## Block 8, Central Park – Response to Submissions

### City of Sydney (CoS)

DWG TITLE  
**LEVEL 8**  
 DWG NO SK:105 REV A

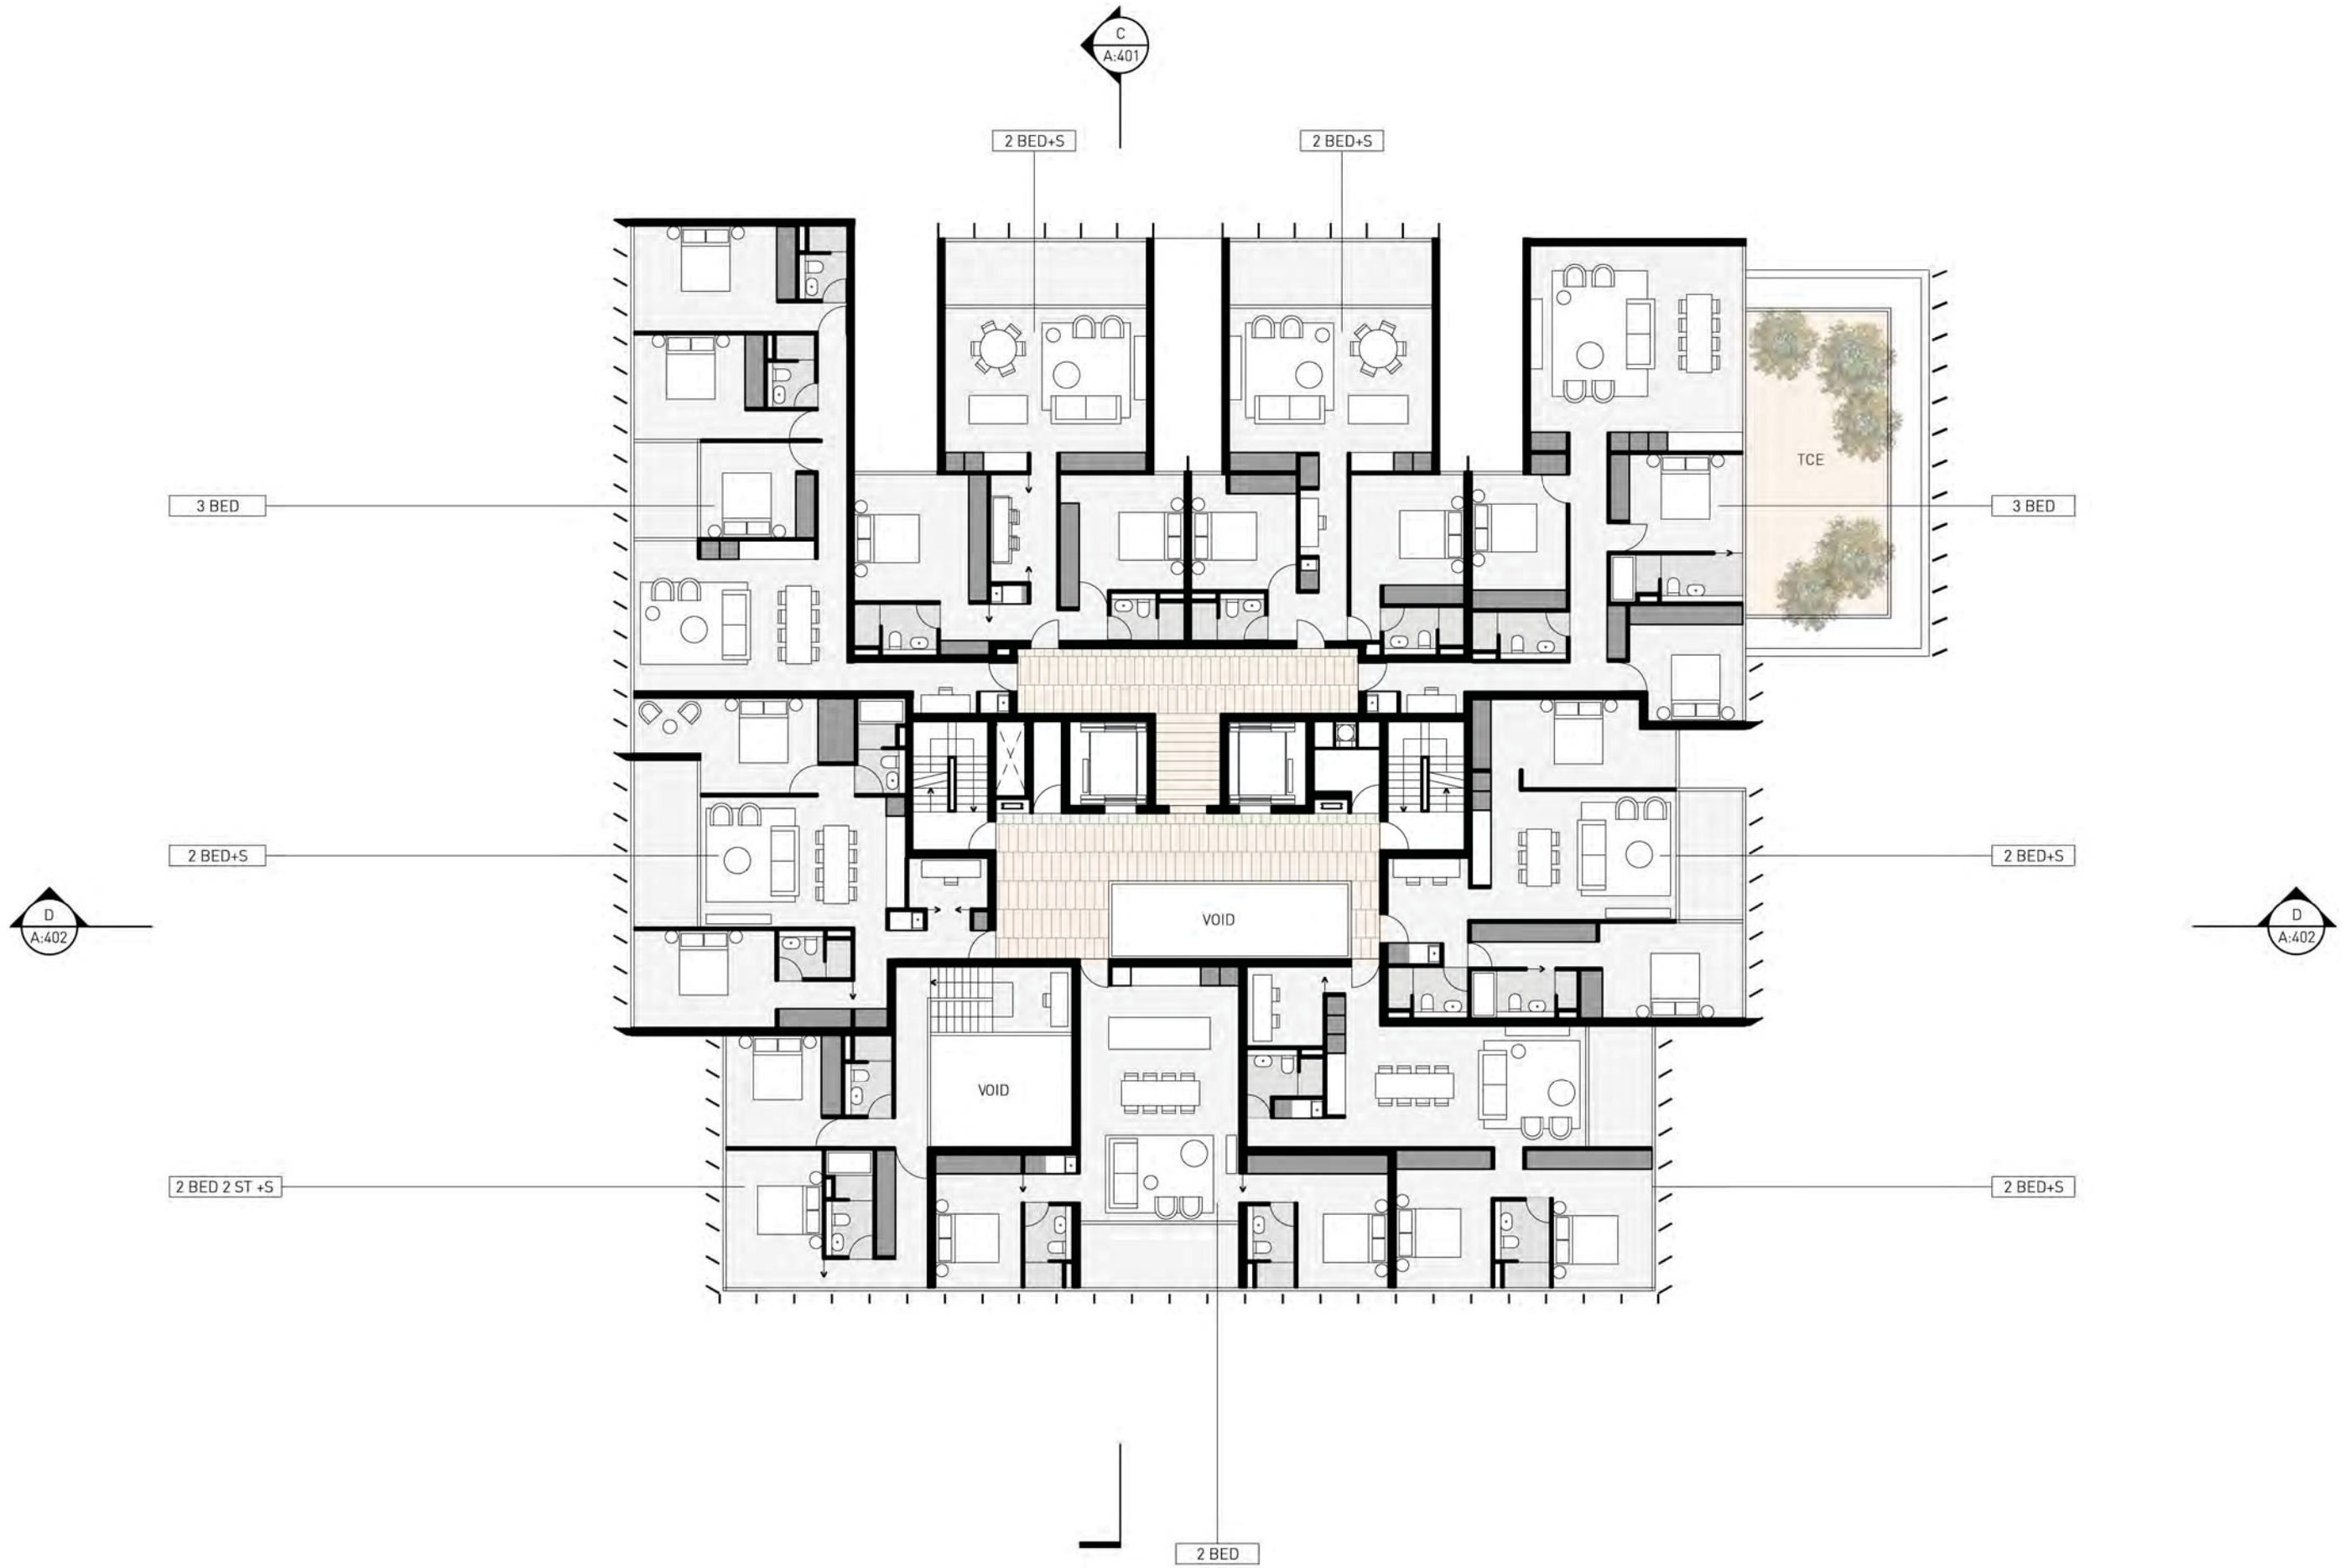
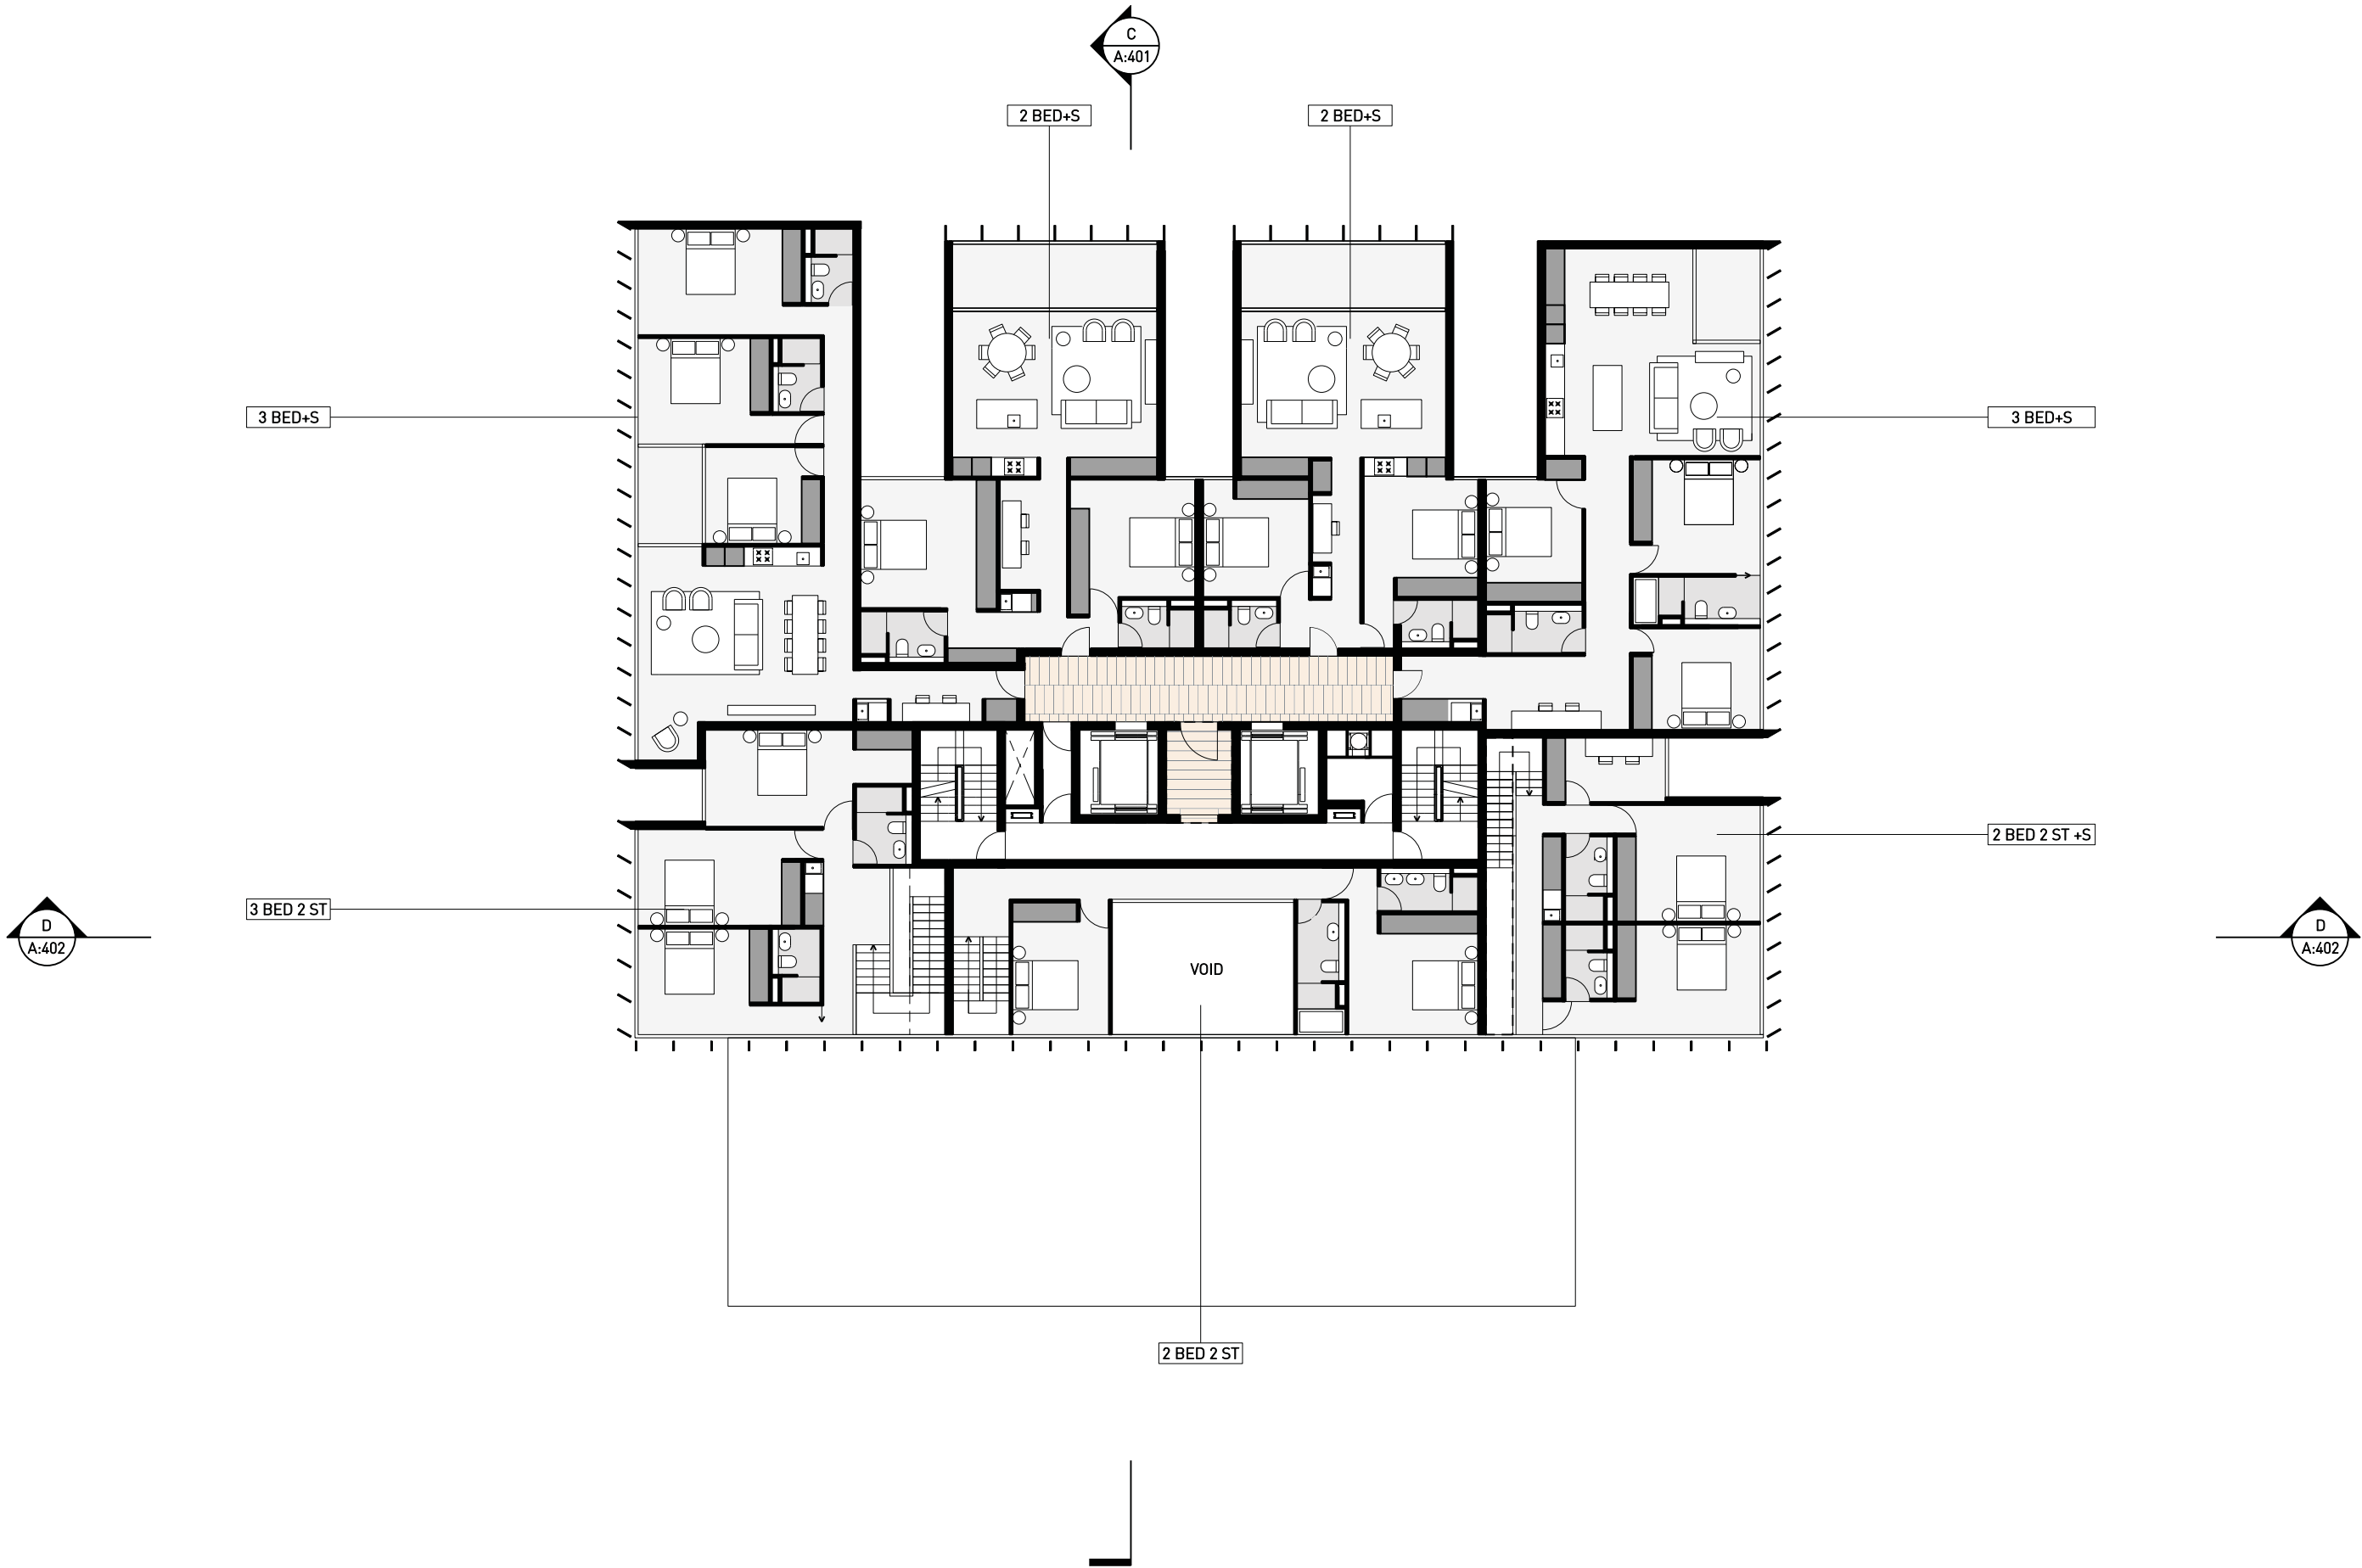
6.	<b>Acoustic Privacy</b> <ul style="list-style-type: none"> <li>▪ Private open space/loggias to apartments located on the north-western corner of the building on Levels 8 to 11 (inclusive) are adjacent to the bedroom of the apartments located immediately to the east. The potential transfer of noise from use of private open space of one apartment to the quieter uses (i.e. bedroom) of an adjacent apartment is inconsistent with the acoustic privacy objectives in the RFDC and will likely result in unreasonable amenity impacts.</li> <li>▪ The City recommends that the applicant be required to amend the layout of apartments to address this issue.</li> </ul>	The layout of the apartments, specifically the bedroom and balcony configuration, has been amended to mitigate the potential transfer of noise (see <b>Appendix A</b> ). In particular, acoustic privacy between apartments is optimised by locating the same functions adjacent to each other. In situations where a living room / kitchen window is adjacent to a bedroom window of a neighbouring apartment, a fixed window is provided to the living room / kitchen with natural ventilation provided by the expanse of operable floor to ceiling doors to the main facade.
